13th August 2012

Application for Householder Planning Permission

Development Hard standing to front of property, dropped kerb & access ramp
Location 65 Foundry Road Yapton Arundel

No.	Description	Date
Amendments:		
Address:	65 Foundry Road Yapton BN18 0HE	Client: Mr A Page
Drawing Title:	Existing & proposed front elevations	Drawing Ref.: SG/02/Found65
Contact Details:		
Contact Address:		
Scale:	Paper:	Date:
1:50	A:2	5/7/2012
Revision No:		Checked By:
		Direction:

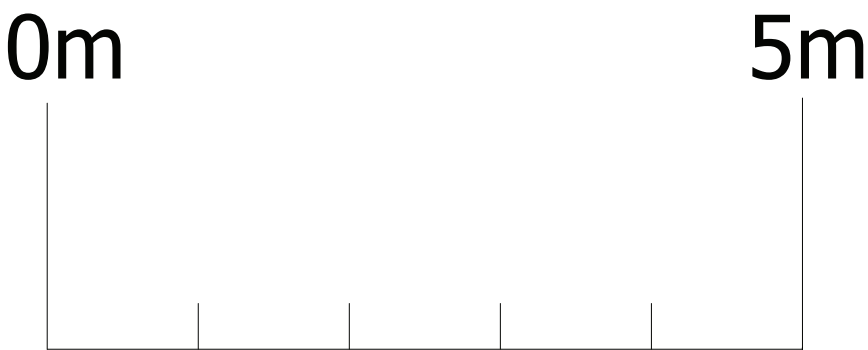
Please provide 1 electronic or 3 paper copies of revised existing and proposed elevations to show a scale. ✓

Site Plan
1:1250

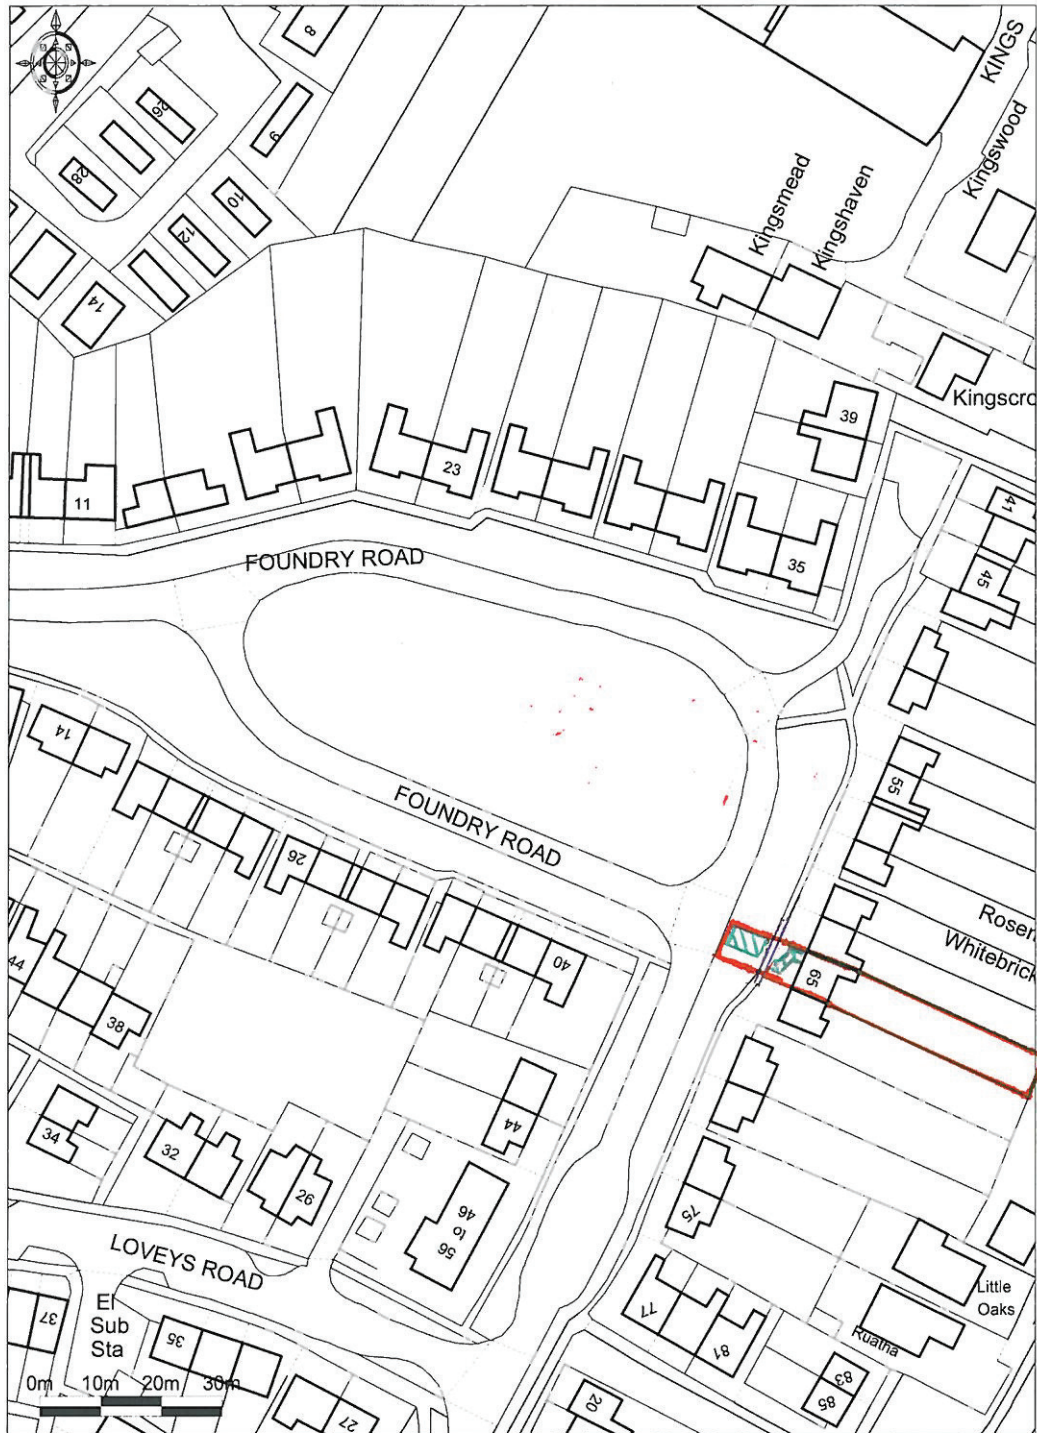
I require 1 electronic or 3 paper copies of a revised location plan showing a red edge around the application site to include the proposed parking space. +

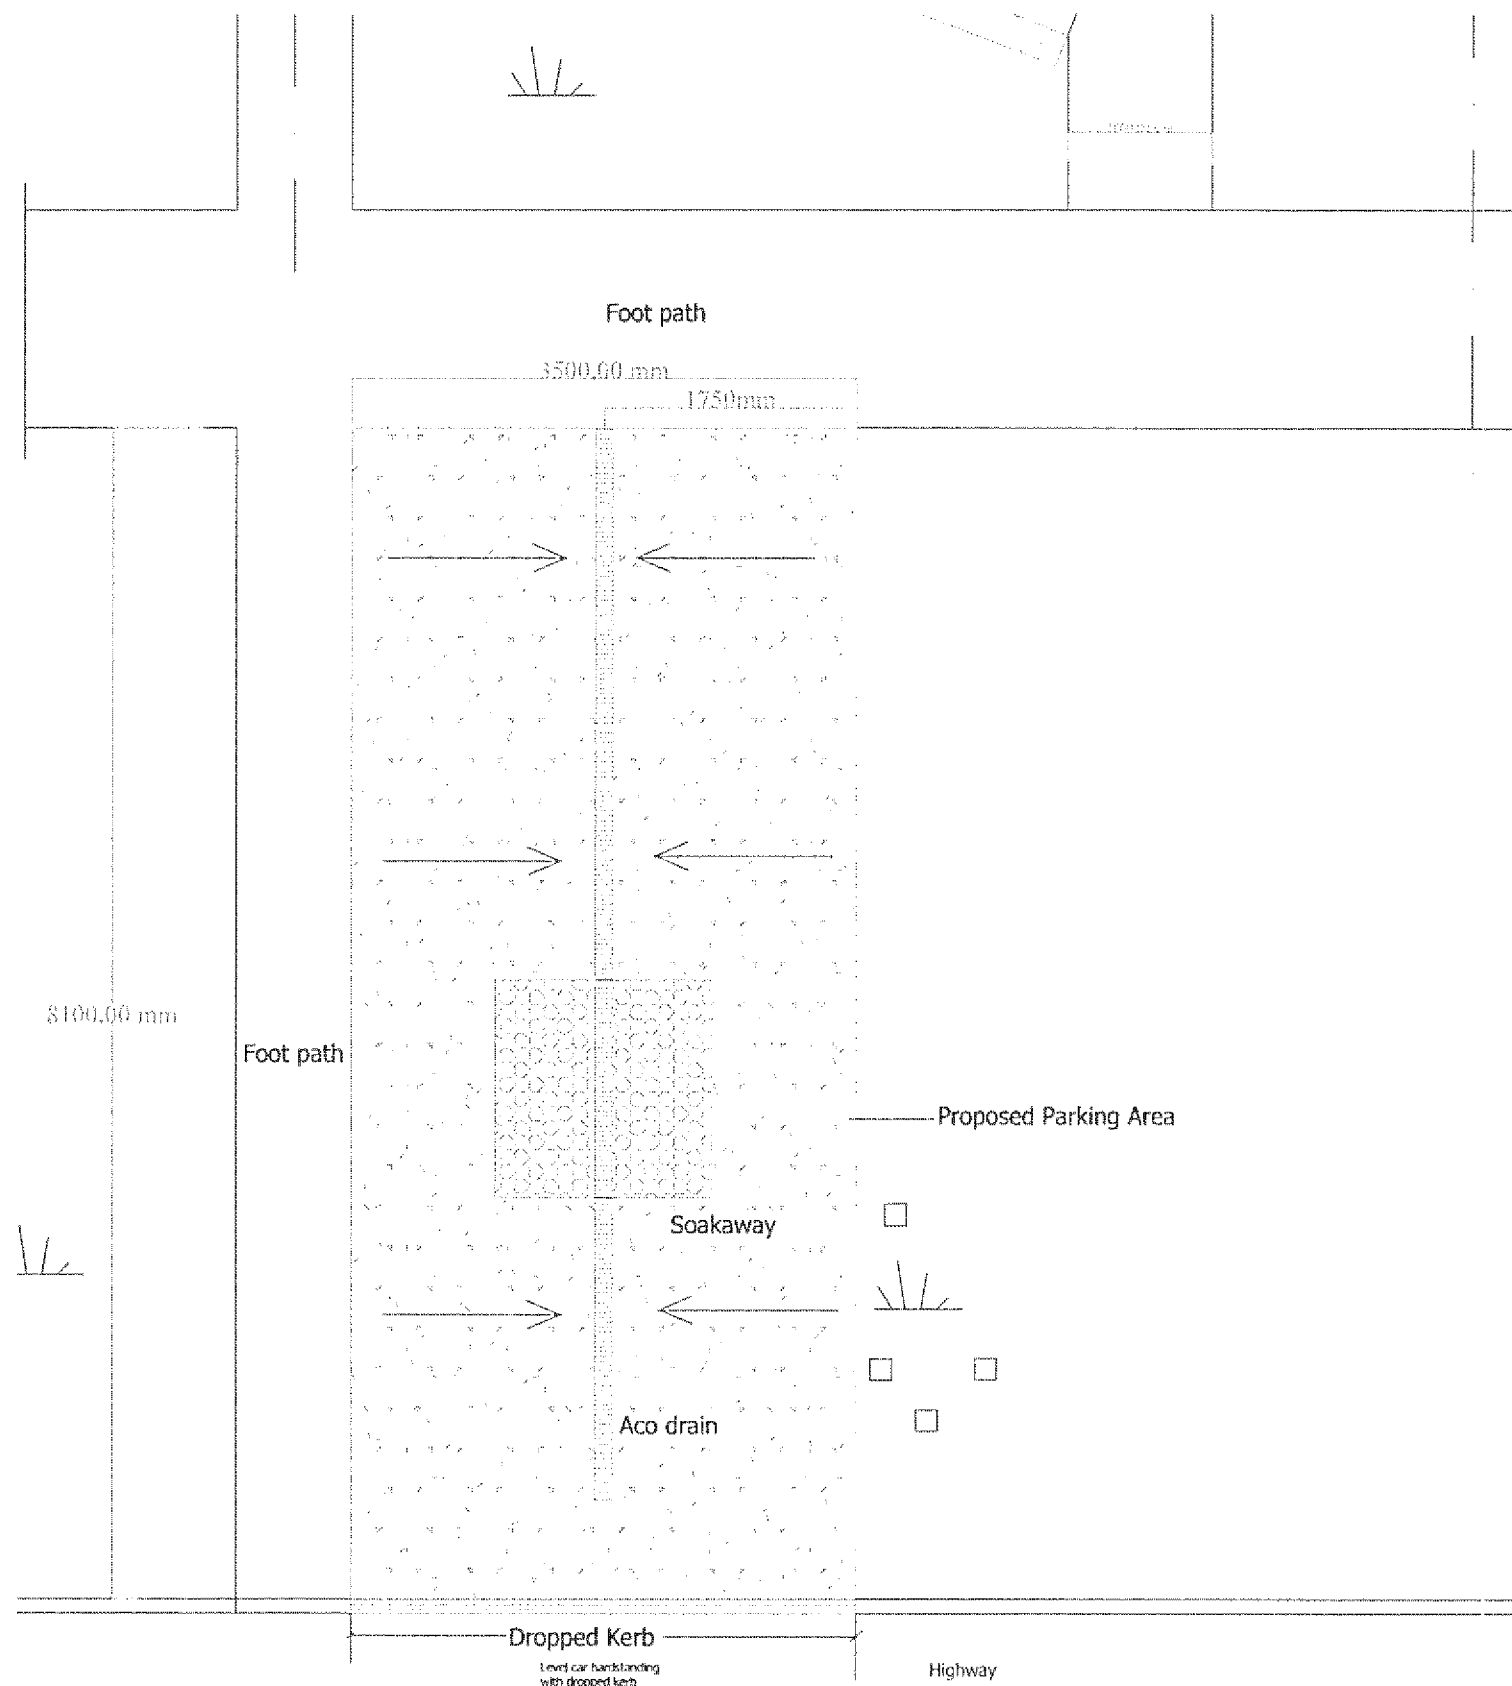
I require 1 electronic or 3 paper copies of a revised block/site plan showing a red edge around the application site to include the proposed parking space (please also highlight the proposed works either with another colour (as previously provided) or hatched). +
